Rosefield Solar Farm – Deadline 6

CSAG Response to Applicant's Position Paper on Arable Field Margins and Hedgerow Mapping [REP5-094] and CSAG comments on Applicant's latest revised BNG Metric calculation [REP5-056] and BNG Assessment [REP5-058]

REV 01

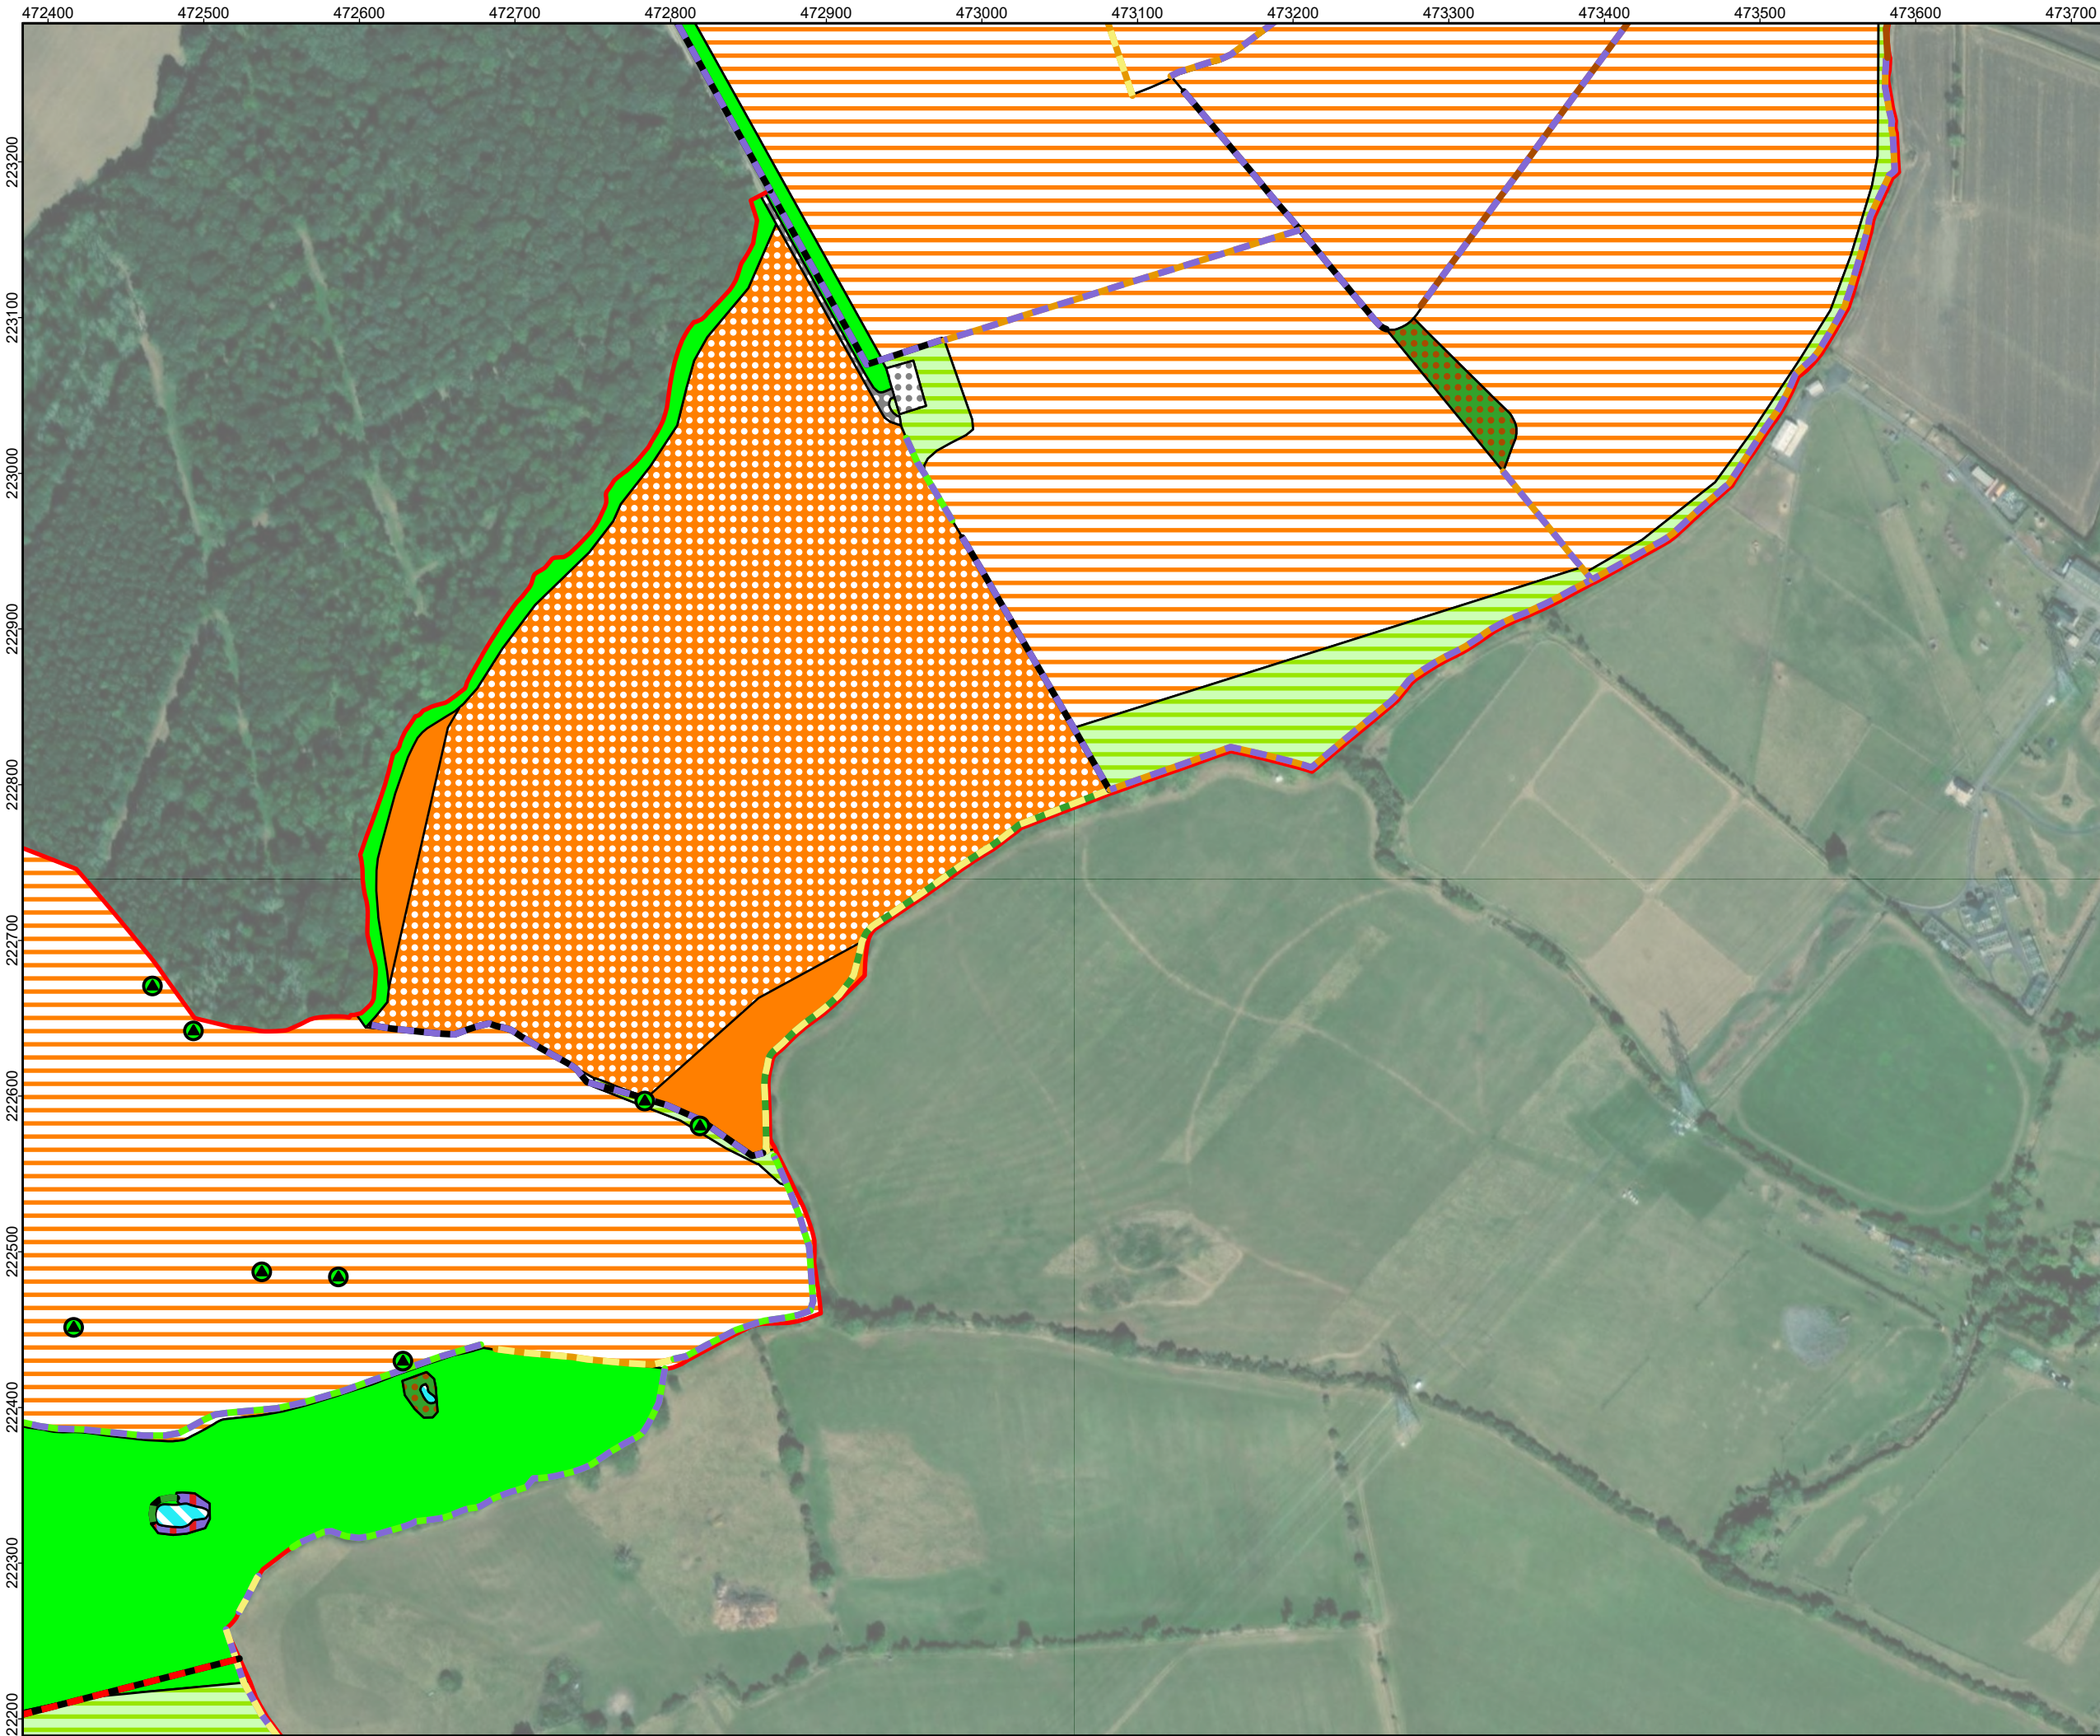
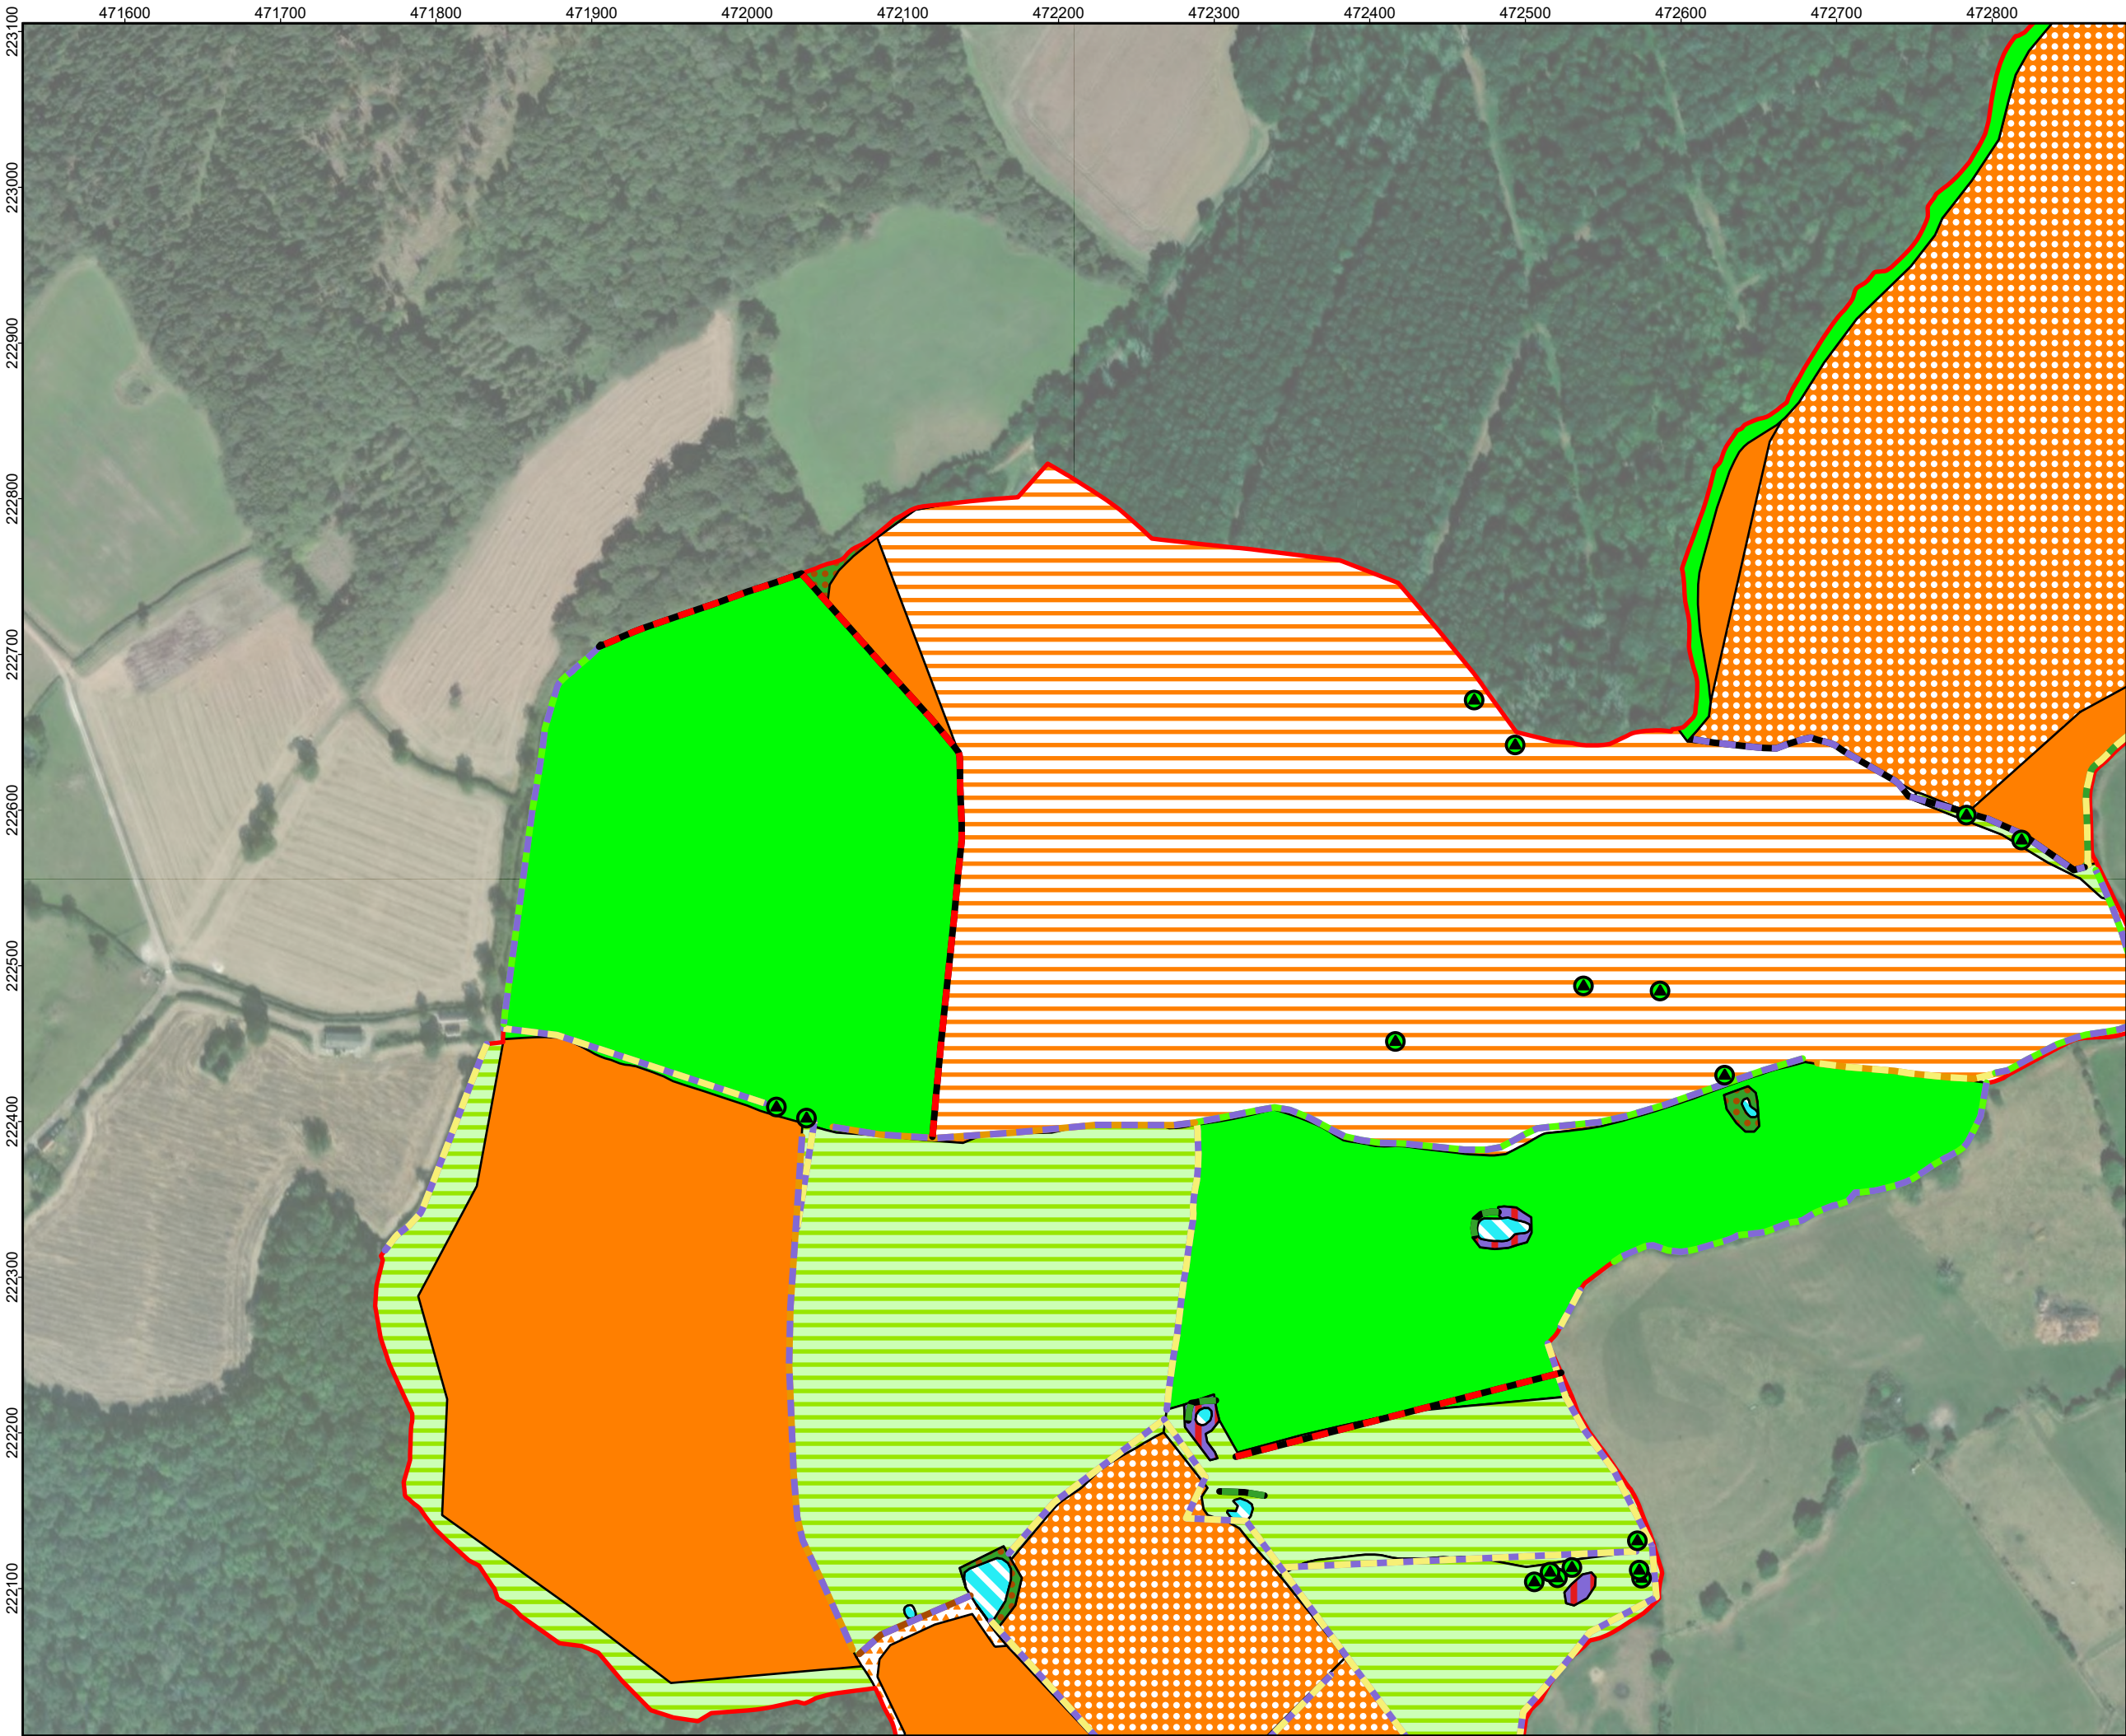
- 2.1 The Position Paper defends the Applicant's approach to classification of habitats at narrower field margins and beneath hedgerows as 'cropland' via a misinterpretation of the Statutory Metric User Guide requirement that habitats should be mapped 'to the centre line of the hedgerow'. The premise that habitat mapping should extend to the centreline of any hedgerow is not, and never has been, the substance of the dispute. It is of course the case that no areas of the site should be left as blank or white land – i.e. unmapped, unclassified and unscored. CSAG have never contested otherwise.
- 2.2 The question of concern to CSAG is about how habitats within two metres of, and extending beneath, hedgerows (especially where adjoining active arable land), once mapped, are then classified and scored, not whether they should be mapped or not.

- 2.3 What the Applicant has done (and inexplicably seeks to continue to defend) is classify, map and score such areas and their non-cropland habitats simply as a continuation of the adjacent cropland. The Applicant continues to try and justify this approach in some instances by reference to the 'minimum mapping units' of the UKHab regime, but (presumably in recognition of the fact that the size of these areas logically exceeds any rational application of MMU in all instances) it seems to have retreated from that defence.

- 2.4 CSAG has consistently pointed out that classifying, mapping and scoring land at arable field margins and extending beneath hedgerows as a continuation of the adjacent cropland is not only (and indisputably) wrong as a matter of fact and on the ground, but the approach of classifying and scoring these strips of land as cropland also introduces two forms of error bias into the calculations, both of which unjustifiably elevate the output BNG score.

- 2.5 The first source of bias is that this approach has a suppressing effect on the baseline value of these areas in the BNG calculation (as cropland scores lower than unmanaged field margin grassland for example). The second is that it adds an unjustified additional uplift to the post-development score based on a conversion from low-scoring cropland to higher-scoring grassland, when such habitats are generally already grassland or ruderal habitat, not cropland.
